File No: SF16/20283
Ref No: DOC16/230803

RE: SYDNEY METRO (CHATSWOOD TO SYDENHAM) (SSI 7400) – NOTICE OF EXHIBITION

Blues Point temporary site – artist's impression (zoomed) from viewpoint 5, Sydney Opera House forecourt

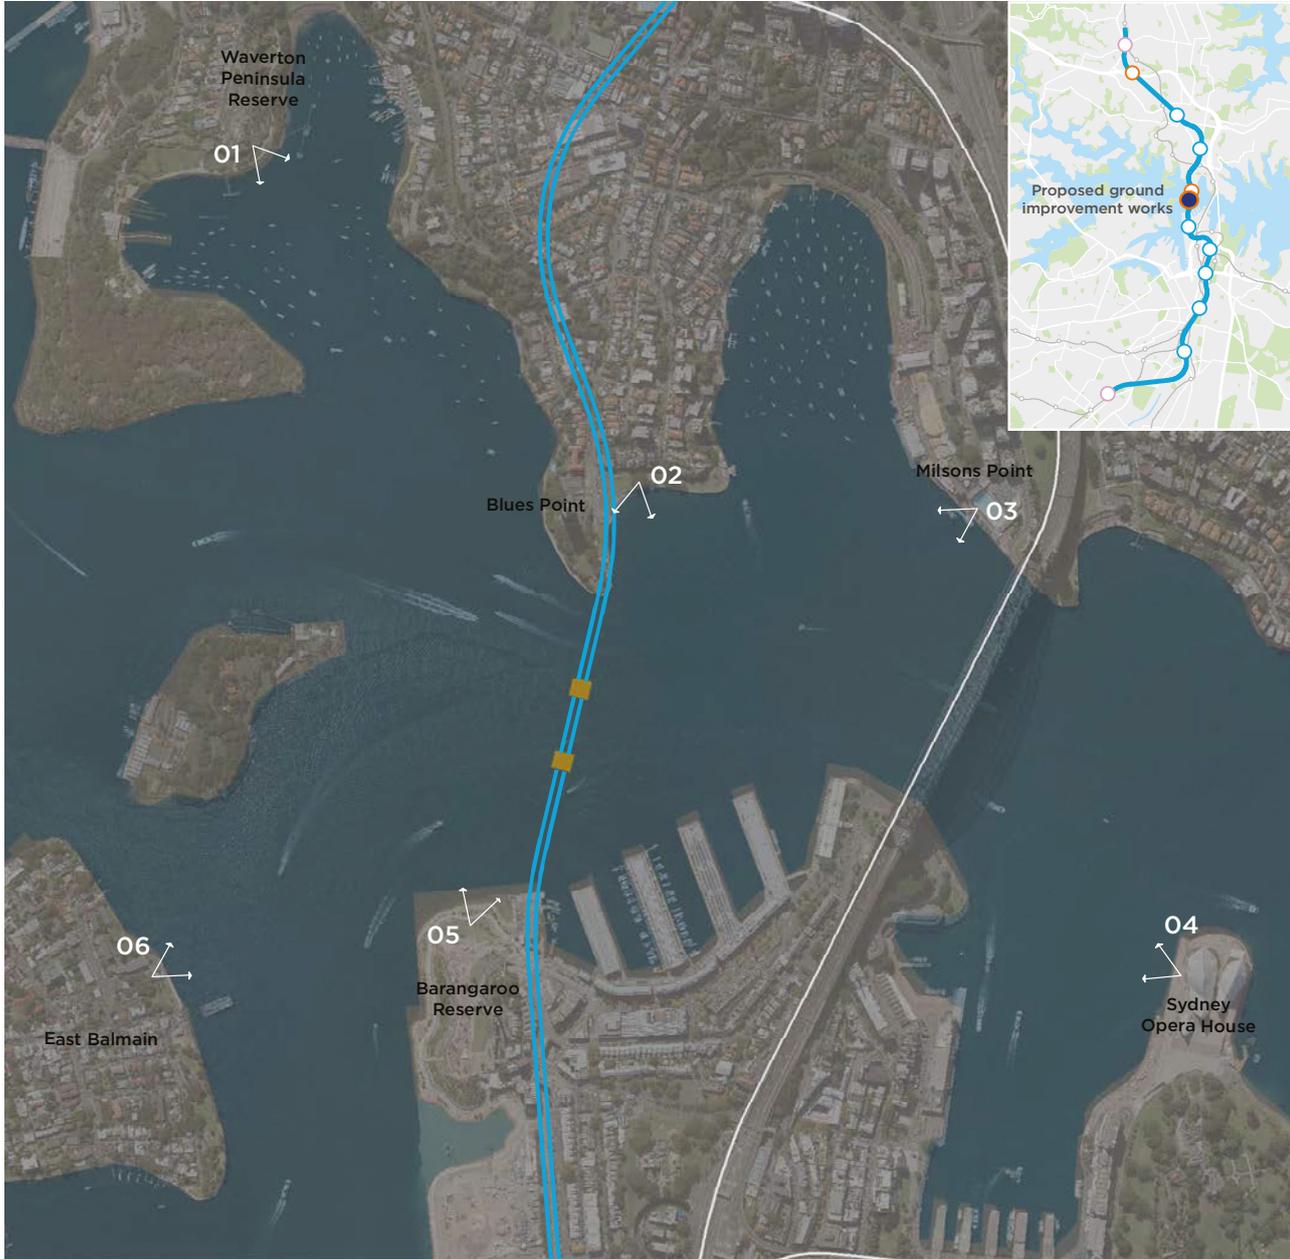
Given the potential state significant archaeology present at this location the Heritage Council considers that an appropriately detailed site specific archaeological assessment, methodology and research design should be completed for the Blues Point Temporary Site prior to approval of the project. This report should be provided to the Heritage Council for comment and endorsement. This assessment should consider mitigation options to limit the impact to any archaeology present.

Barangaroo Station – artist's impression from viewpoint 5, Hickson Road

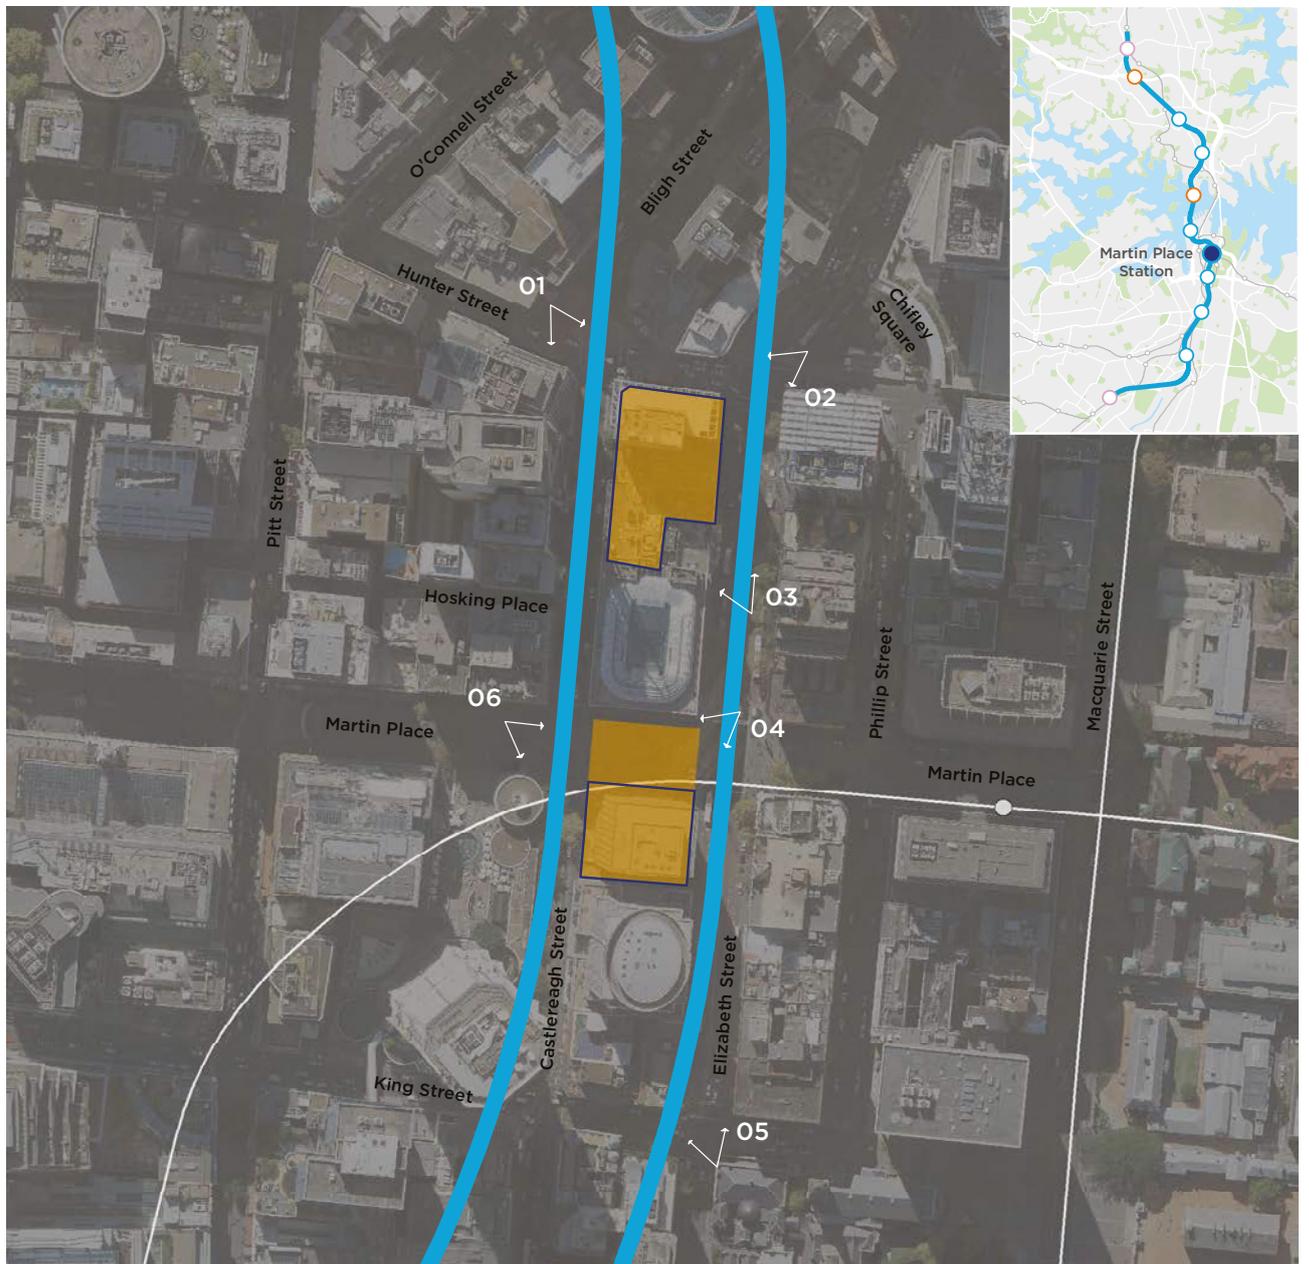
Above ground impacts posed by the proposed Barangaroo Station are primarily associated with impacts to views and setting from the station entrance structures and service buildings. The proposed ventilation risers and skylights fronting the Hickson Road wall would be within the precinct and will have an adverse impact on the views to the precinct and the Hickson Road wall from the Barangaroo Development Area. The Heritage Council is concerned regarding these impacts and is of the view that *integration of station and rail facilities to the Barangaroo development can prevent or minimise impact to the Hickson Road wall that is the only remaining significant feature of the Hungry Mile.*

- All station and rail facilities for Barangaroo Station must be integrated with the Barangaroo development to minimise impact to the Hickson Road wall, the only remaining significant feature of the *Hungry Mile* that forms part of the Millers Point and Dawes Point Village Precinct.
